APPLICATION NO. 03DRB-01338	PROJECT NO. 1002879
PROJECT NAME LOTLINE ADJ, SYMPHONY SUBD. LOTS 22-24	
EPC APPLICATION NO.	
APPLICANT / AGENT HALL SURVEYING ENGINEERING	PHONE NO. 848-7822
ZONE ATLAS PAGE H-13	RICHARD HALL

## ONE STOP COMMENT FORM LOG

VICINITY MAP SCALE: 1" = 750'  NORTH

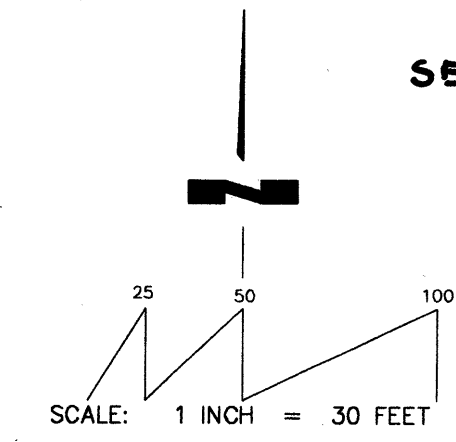
TRANSPORTATION DEV (505) 924-3990		
PLANS DISAPPROVED	DATE	DATE
PLANS APPROVED <i>AD</i>	DATE 8-12-03	DATE
COMMENTS:		
Vicinity MAP is incorrect
